From: Amanda Scholes on behalf of Planning.Responses
Sent: 14 January 2021 12:09
To: Planning Scanning
Subject: FW: Planning Consultation on: Y/140/20/DOC

From: Laura Gibbons <Laura.Gibbons@arun.gov.uk>
Sent: 13 January 2021 09:42
To: Planning.Responses <Planning.Responses@arun.gov.uk>
Cc: Simon Davis <Simon.Davis@arun.gov.uk>
Subject: RE: Planning Consultation on: Y/140/20/DOC

Application No: Y/140/20/DOC

Site Address: Cinders Lane Nursery And Works To The Rear Cinders Lane Yapton BN18 0JJ

HB1, Hydro Brake Manhole & Discharge from Sub Base Attenuation Details

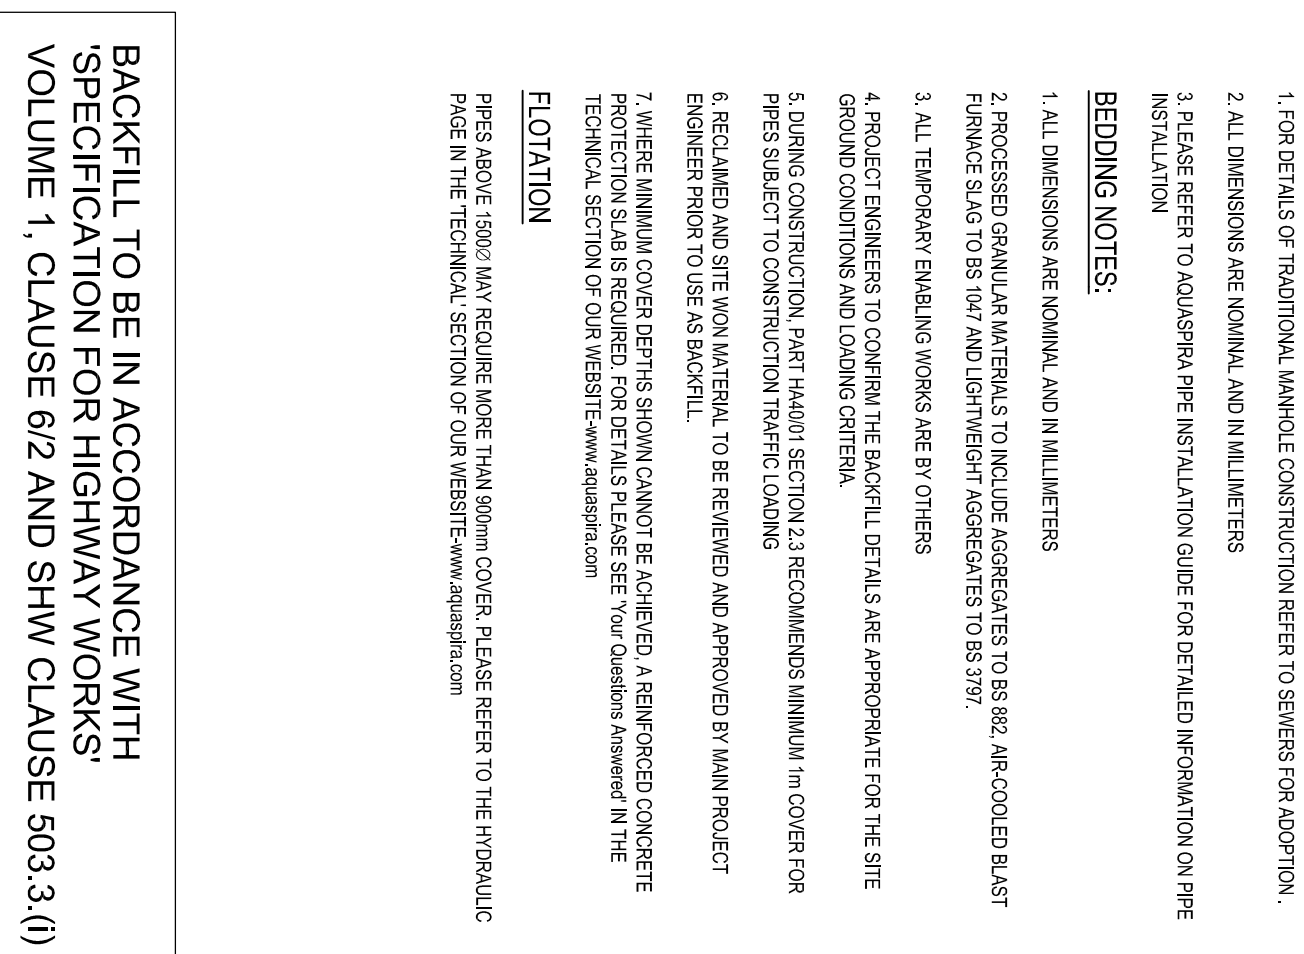
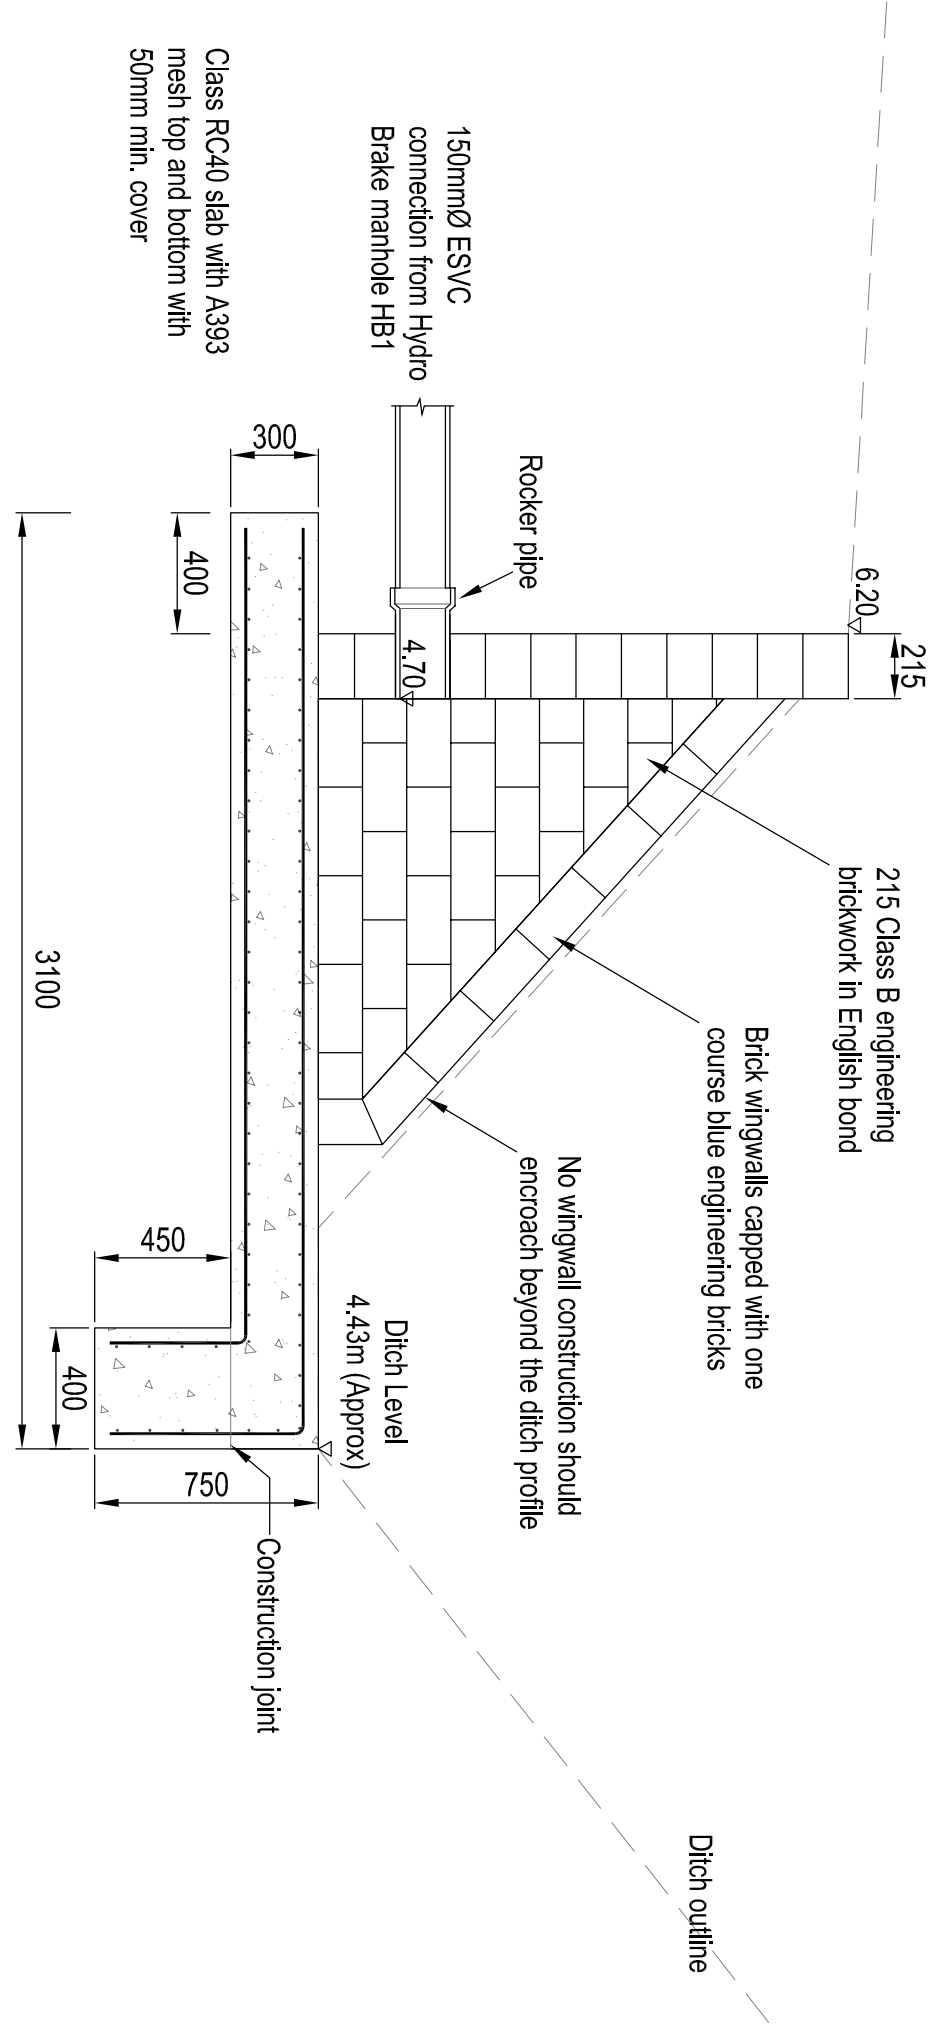
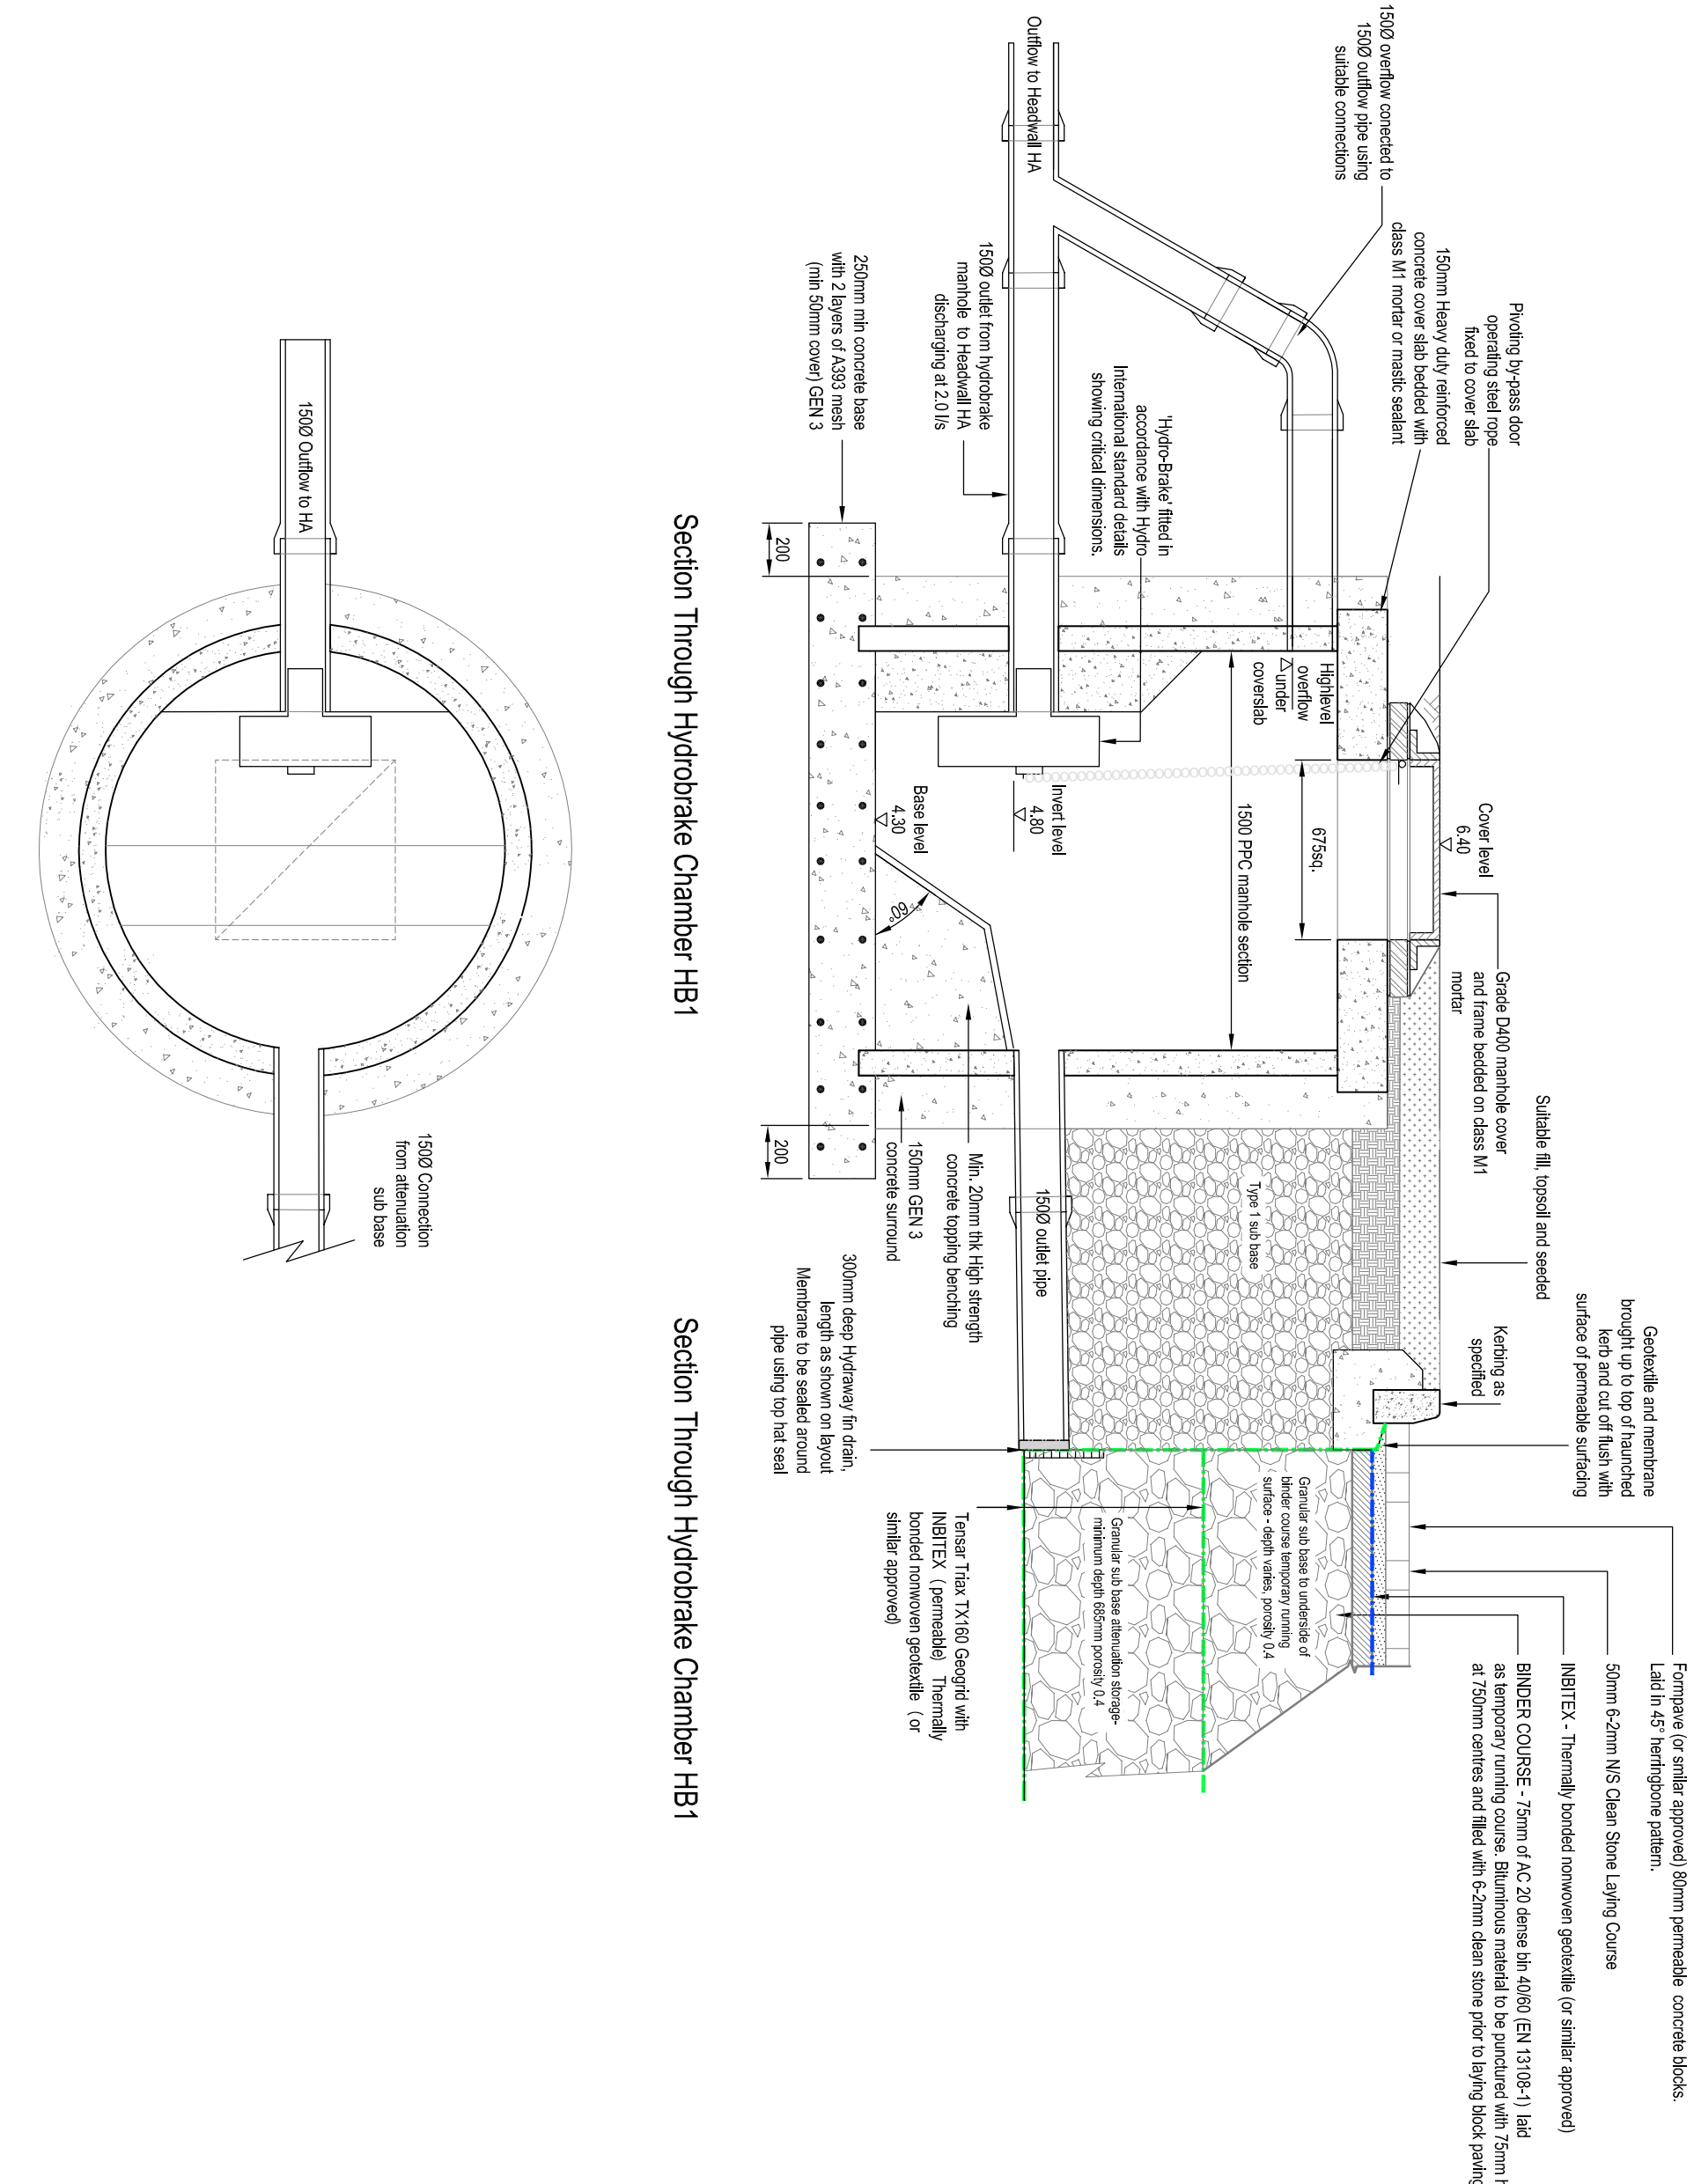
30. Specify hydrobrake model on HB1 construction detail drawing. Specify ST4 concrete base, benching and block for hydrobrake fixing. Specify overflow invert level and surround pipe in min. 150mm thick ST4 concrete. Include step rungs. Specify class B engineering brickwork under cover/frame.

Drawing Title				
Engineering Details				
Standard Construction Details				
Drawing	Contract	Scale	Paper Size	Date
KN		As Shown	A1	12.18
Job No.	Drawing No.		Revision	
KNC2006	501-01		B

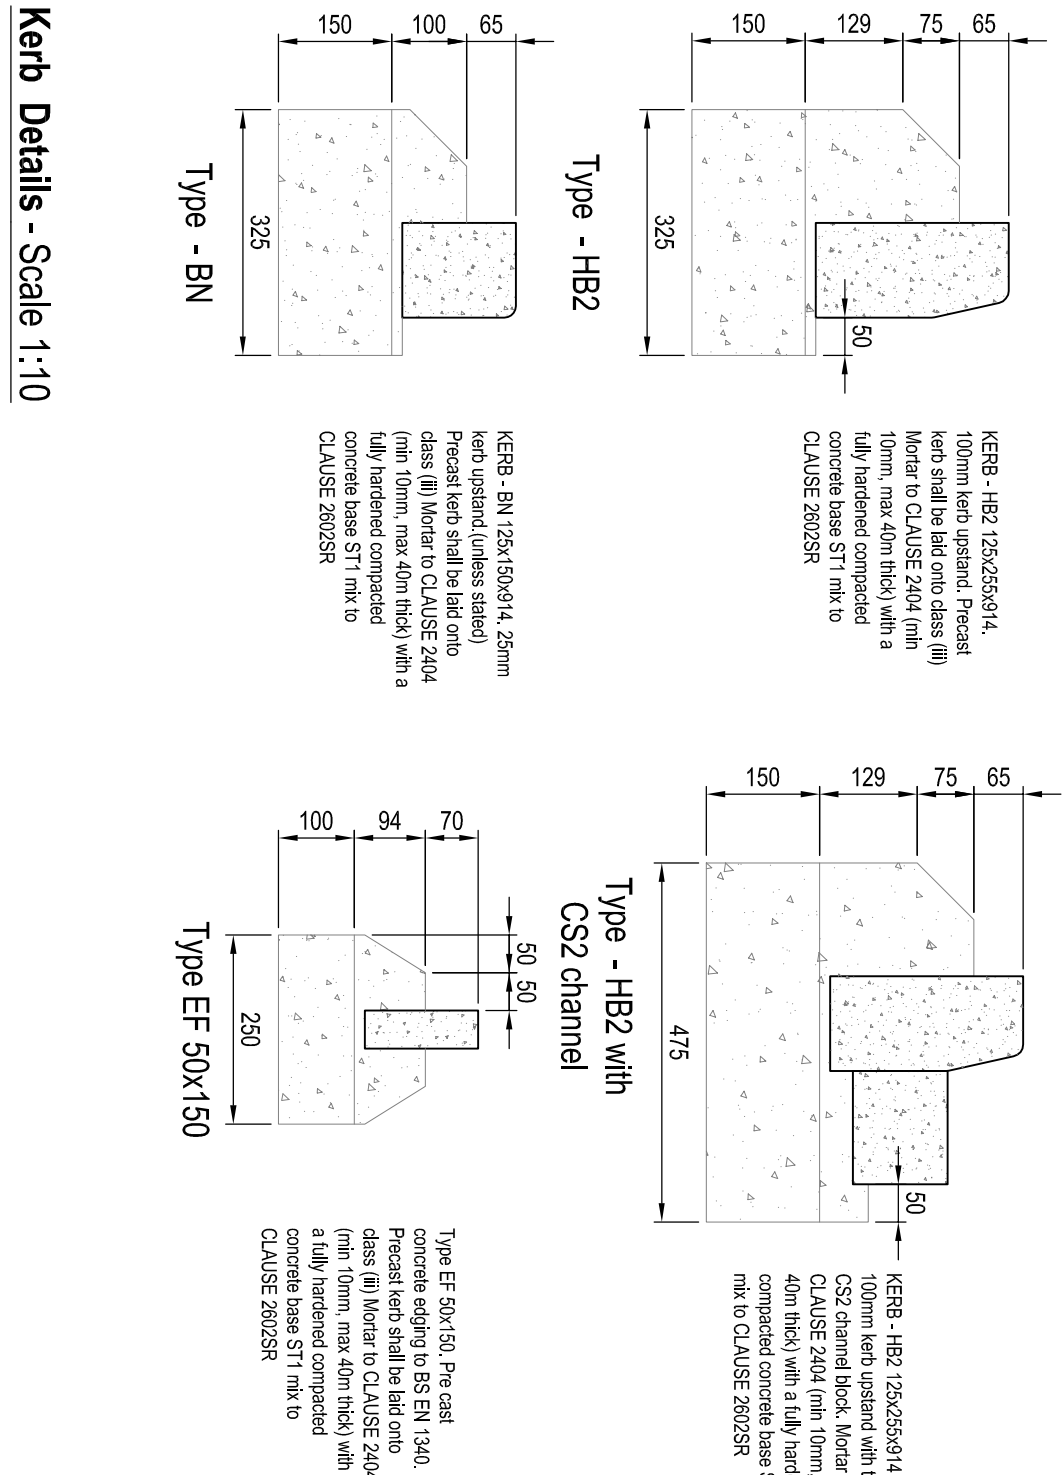
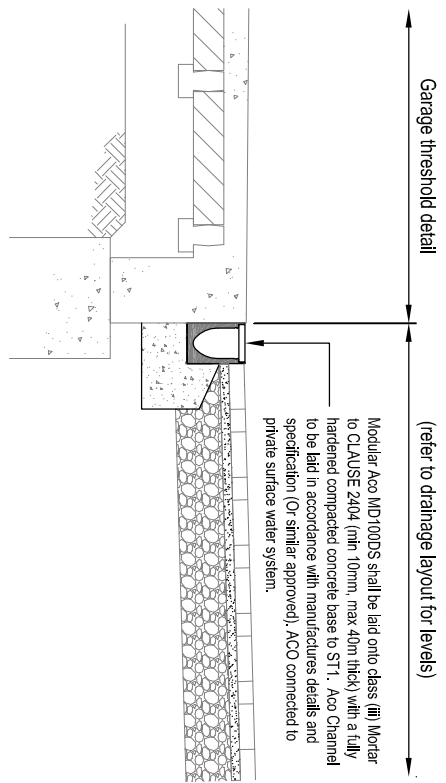
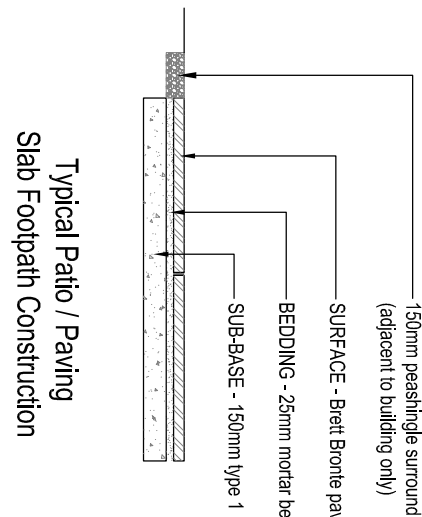
28. Drawing 501-03 Rev A - Aquire Spire storage pipe detail not relevant – delete.
29. Drawing 501 01 Rev B – permeable block paving detail type 3 not relevant? – delete
